REQUEST

Current Zoning: I-1 (CD) AIR (light industrial, conditional, airport noise overlay)
Proposed Zoning: I-2 (CD) AIR (general industrial, conditional, airport noise overlay)

SUMMARY OF PETITION

The petition proposes to allow development of a vacant site with all uses permitted in the I-2 district including outdoor storage of equipment and materials.

Drawing Title:  
**RZP-2021-042 Conditional  
 Rezoning Site Plan**

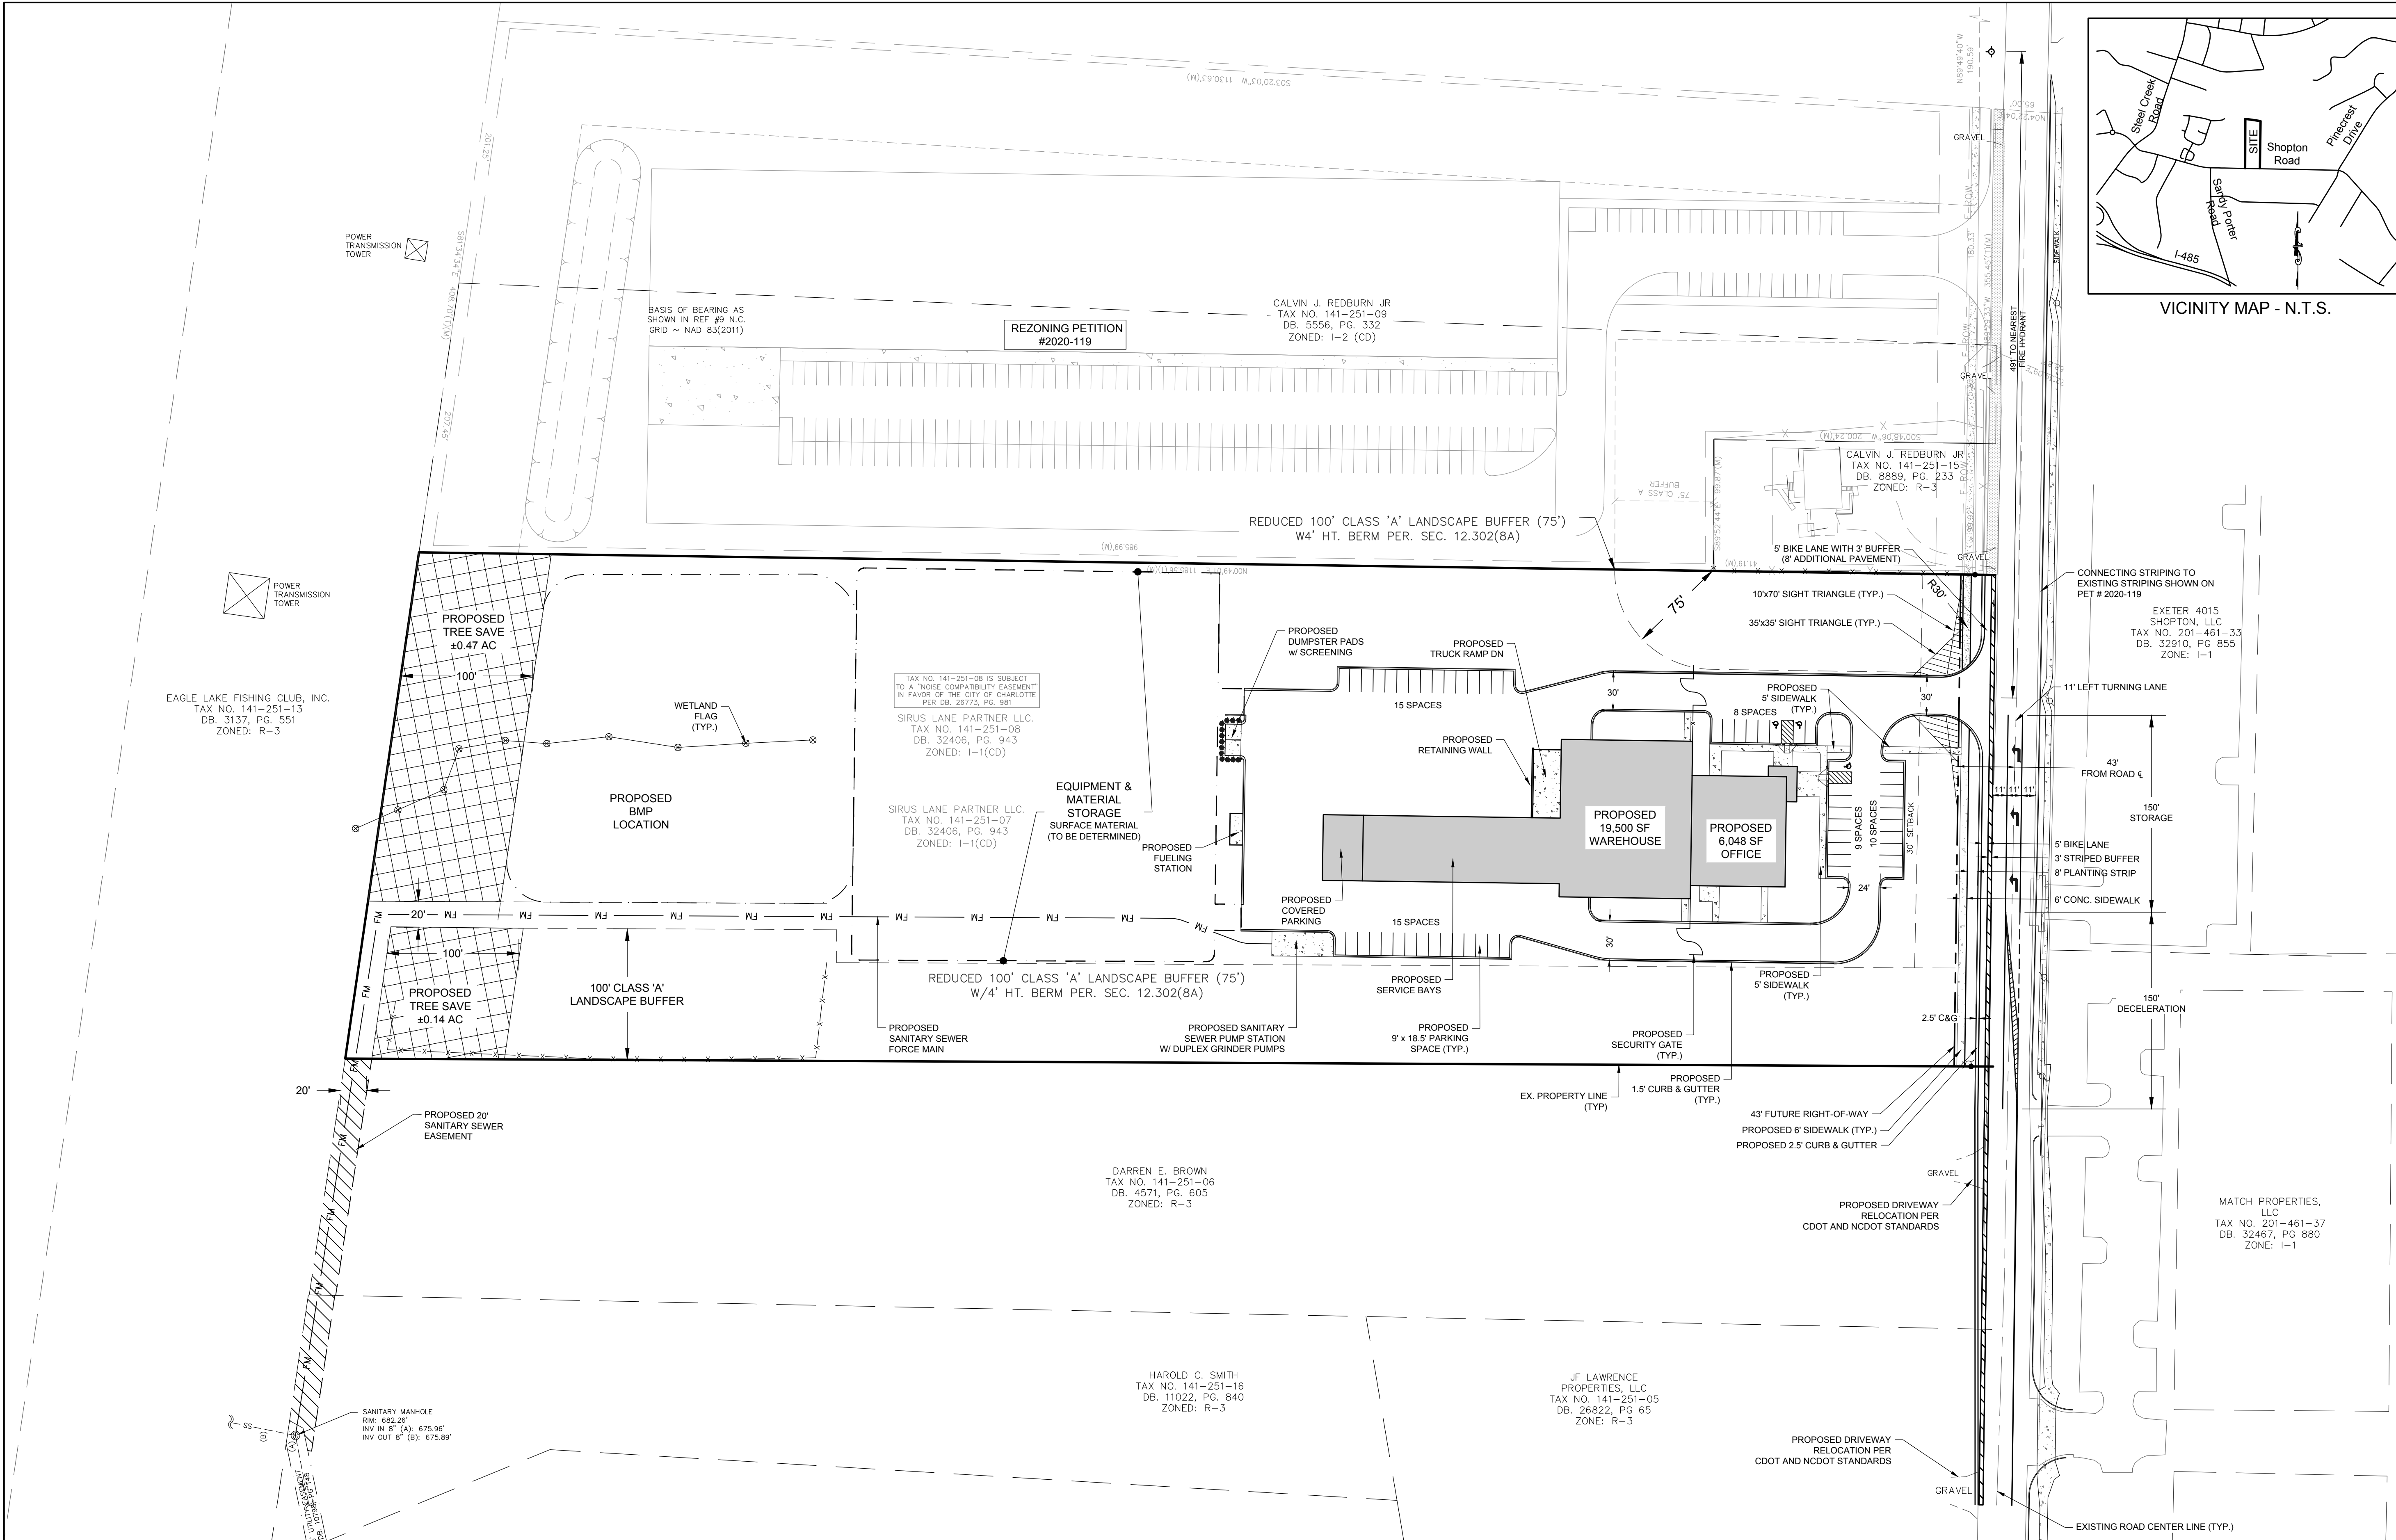
3. ~~Label 100' Class A buffer along property boundary at rear of site.~~ **ADDRESSED**

5. ~~Correct conflicting notes regarding setback width in note V.4.~~ **ADDRESSED**

6. ~~Label and dimension Shopton Road curblin at 27' from centerline to back of curb.~~ **ADDRESSED**

RZP-2021-042 Conditional Rezoning Site Plan

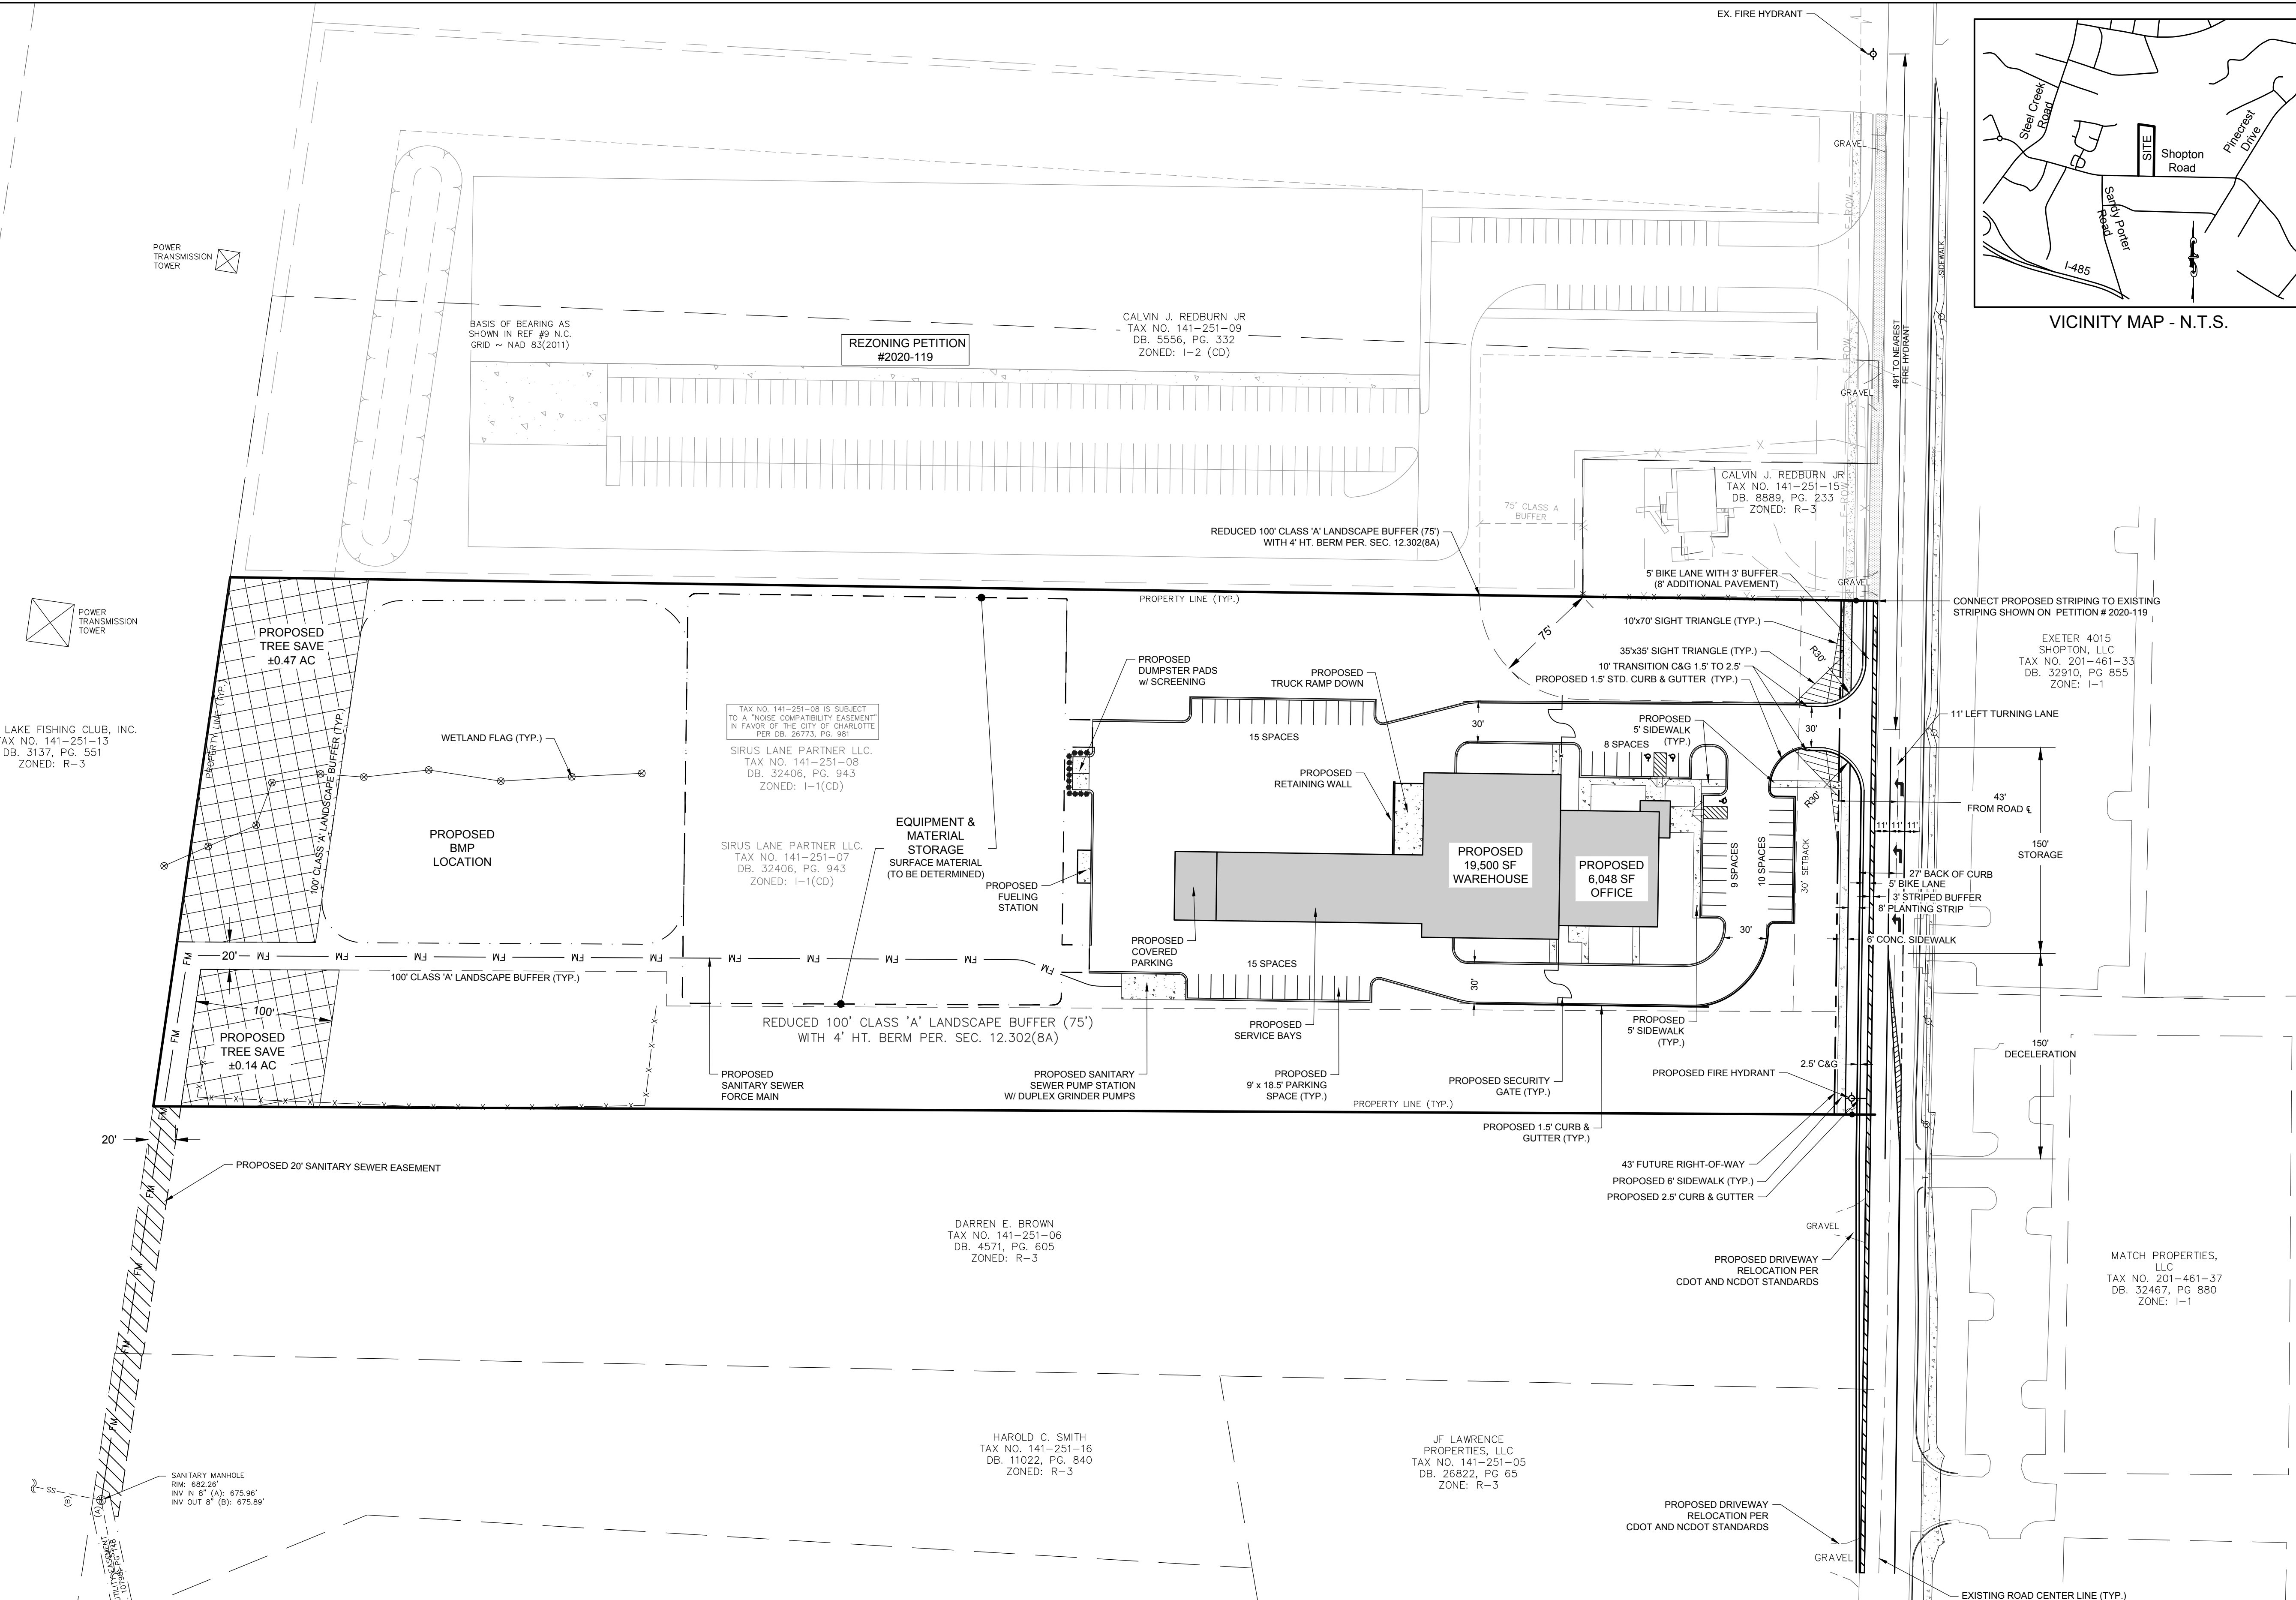
2. ~~Remove "pedestrian scale" from note VII.~~ **ADDRESSED**

7. ~~Revise notes III.5 and III.6 regarding right of way dedication and the timing of completion of transportation improvements as noted in CDOT's memo.~~ **ADDRESSED**
